Arun District Council

Reference: BE/76/15/HH

Location: Spinney Cottage, Shripney Lane

Enquiry: Foreseeable damage to trees for a single story extension

SITE PLAN
SCALE: 1:500

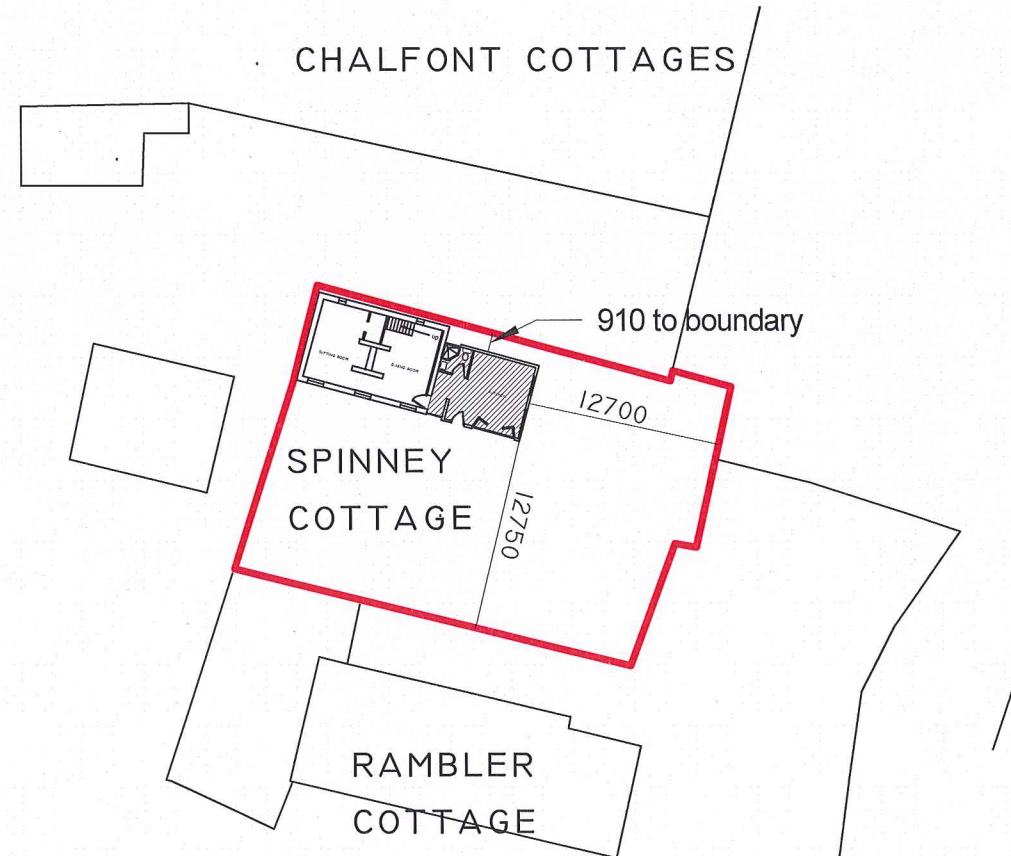
- It is clear from the site inspection that a number of branches will have to be removed to facilitate the proposed single story dwelling; this does include the branches cited in **Fig.1**. It should be noted that the cited Cypress tree has had a previous crown lift (to a height of 4 meters about at some point (judging by the regrowth for at least 3 years ago)).

- Judging by the size of the proposed extension, the established pruning points shown in **Fig.1** may have to be taken back further. There is also evidence of a previous lateral reduction to the western extremities of the cited cedar. Again to facilitate the proposed extension a reduction that surpasses the established pruning points may be required.

- A concern should also be given to physically access the site with the containers. As can be seen below in **Fig.2** the lowest south facing limbs may have to be removed to gain access, as the given space may not allow access.

- If the cited limbs have to be removed, then I would have to take issue, as this would mean leaving wounding present of this tree that exceeds 100 mm. This is likely to be detrimental to the trees health and cause a degree of stress. Also this sized wounding will leave it at risk of a pathogens establishing.
